CITY OF ALBUQUERQUE

June 26, 2015

**Re: Sandia Area Federal Credit Union
Erosion Sediment Control Plan
Engineer's Stamp Date 6-22-15 (F22E002)**

**EROSION CONTROL NOTES:**

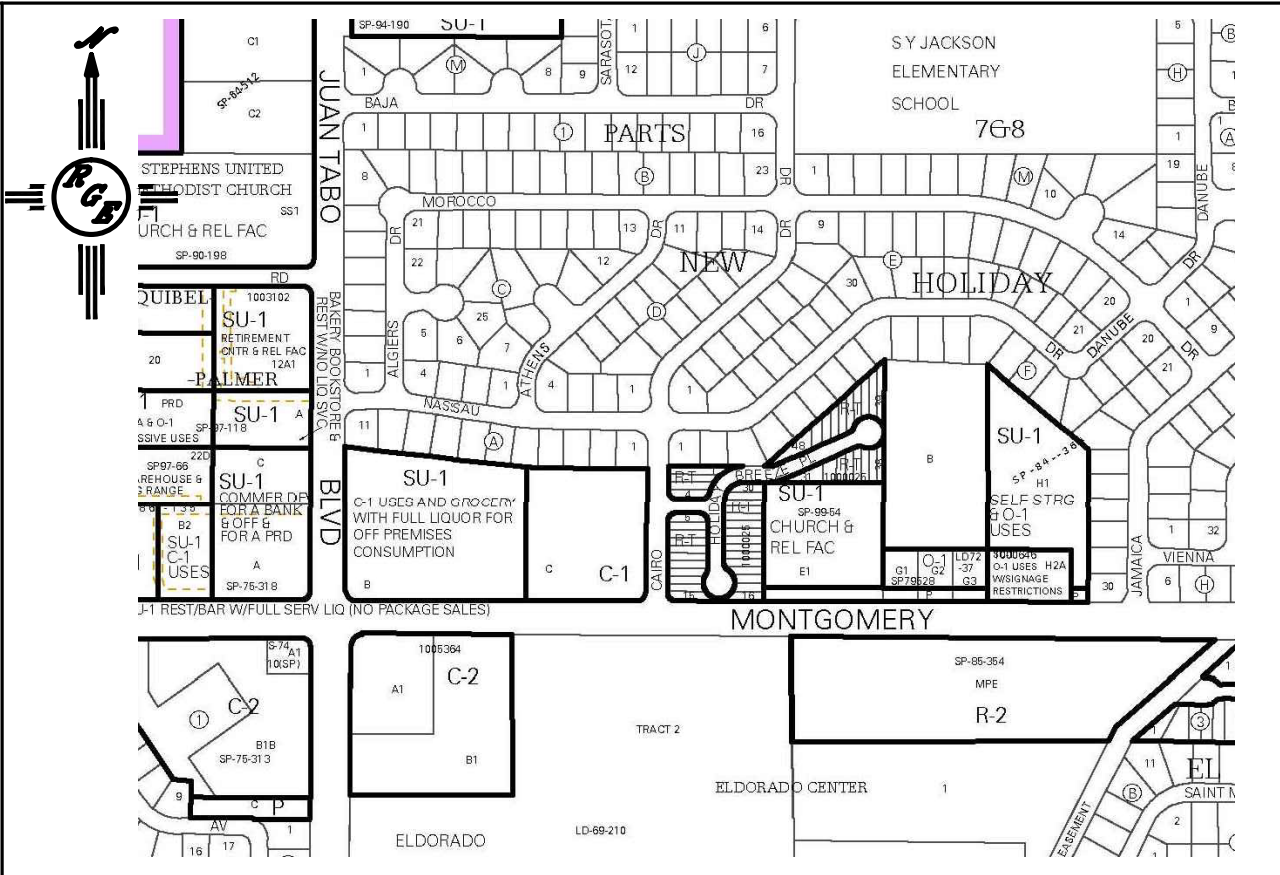
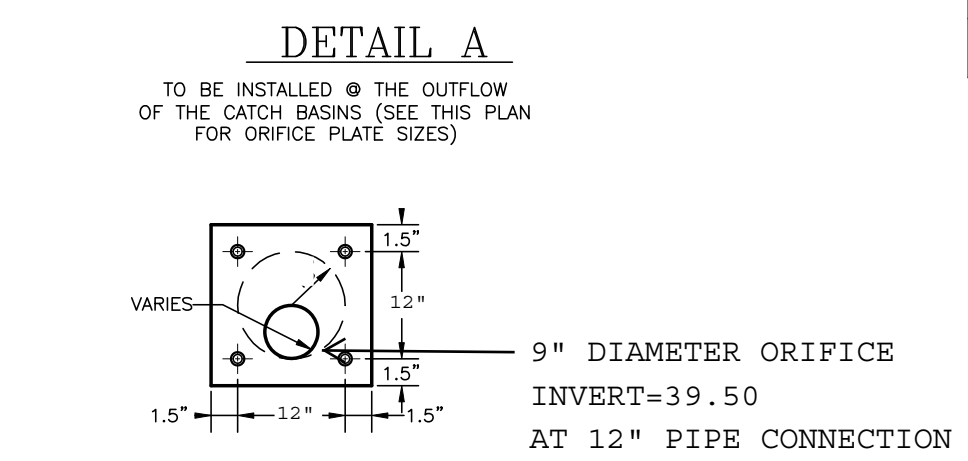
1. Include a waddle at the base of the silt fence in the existing entrance onto Montgomery Blvd and the access on the west side.
2. Provide inlet protection for the three proposed inlets.
